Your ref: SSD-13619238-Mod-3  
Our ref: DOC26/51080

**Subject: Greenwich Hospital Redevelopment Modification 3 - Tree Removal (SSD-13619238-Mod-3) (Penrith)**

CPHR has reviewed the *Modification Application* (Colliers Urban Planning, 28 November 2025), *Appendix A: Landscape Drawings* (Taylor Brammer Landscape Architects, 11 September 2025) and *Appendix B: Arboricultural Statement* (Mark Bury Consulting, 14 August 2025).

TREE RETENTION AND REMOVAL PLAN

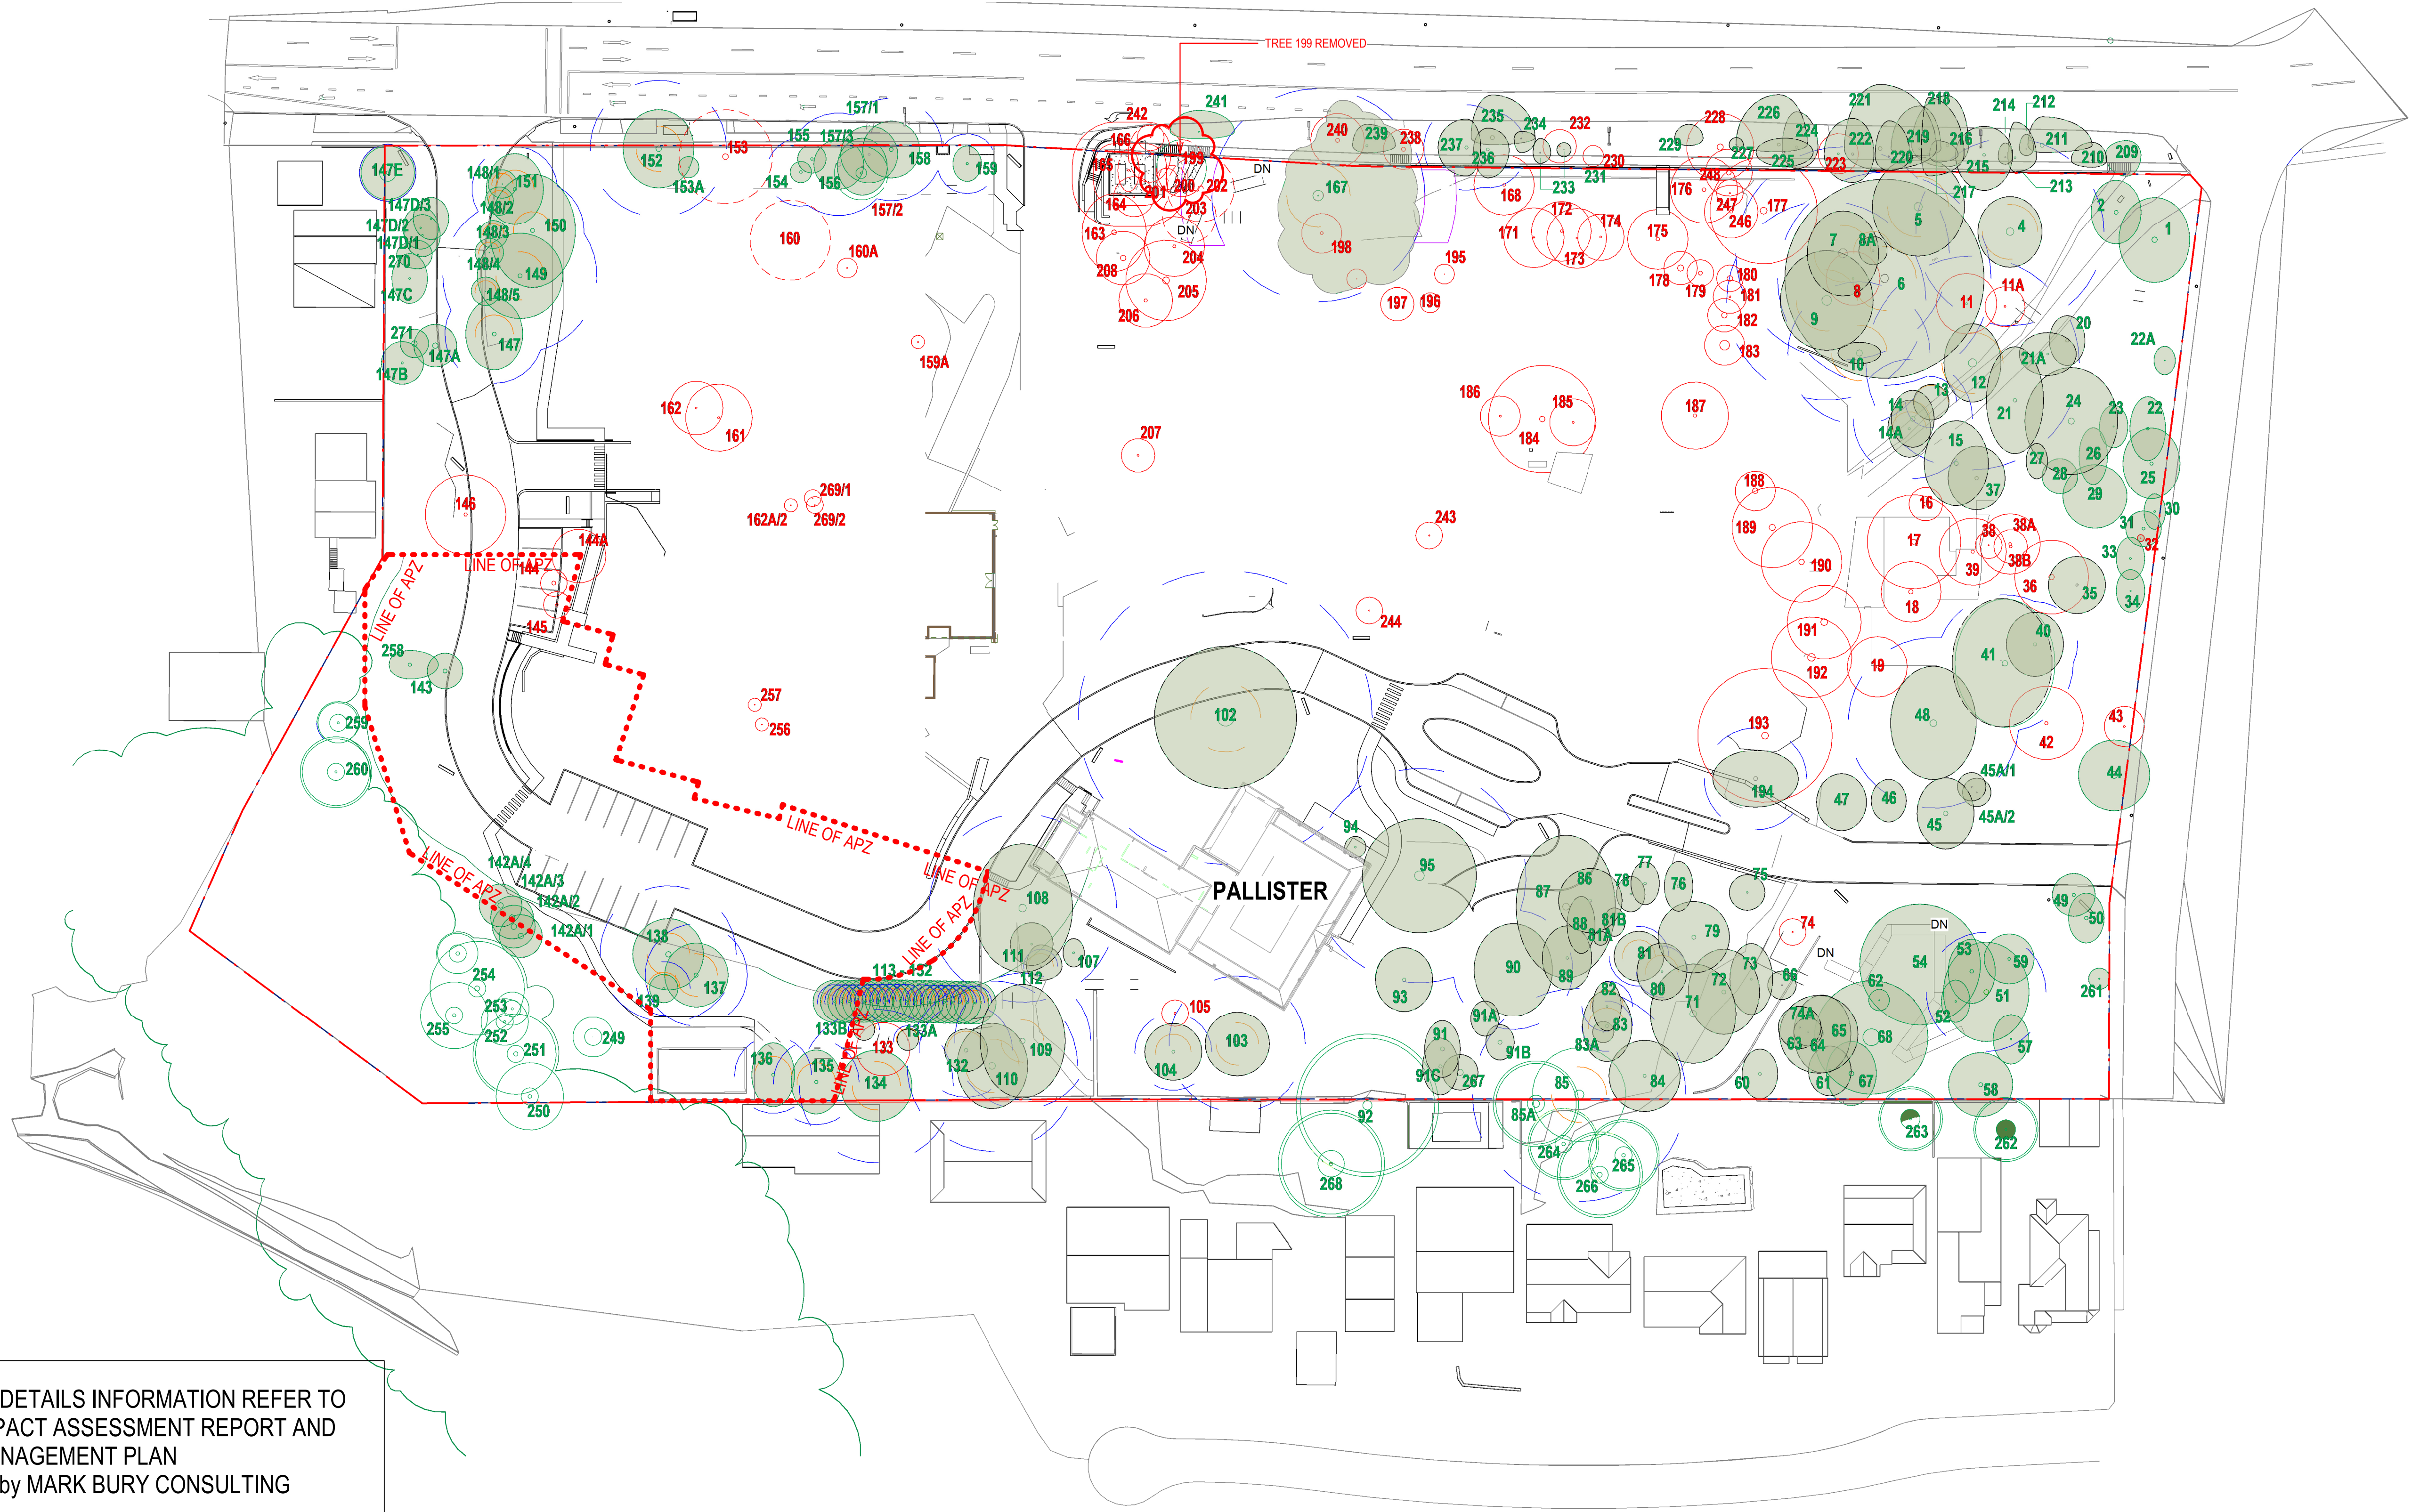
CPHR accepts the arborist's assessment that retention of Tree 199 is not feasible due to the restricted root zone and 50% encroachment into the nominal root zone. As Tree 199 (*Acer negundo*) is listed in NSW as a High Threat Weed, its removal is appropriate. CPHR supports Tree 199's replacement with a Sydney red gum (*Angophora costata*), as it would provide foraging resources for native fauna as the tree matures.
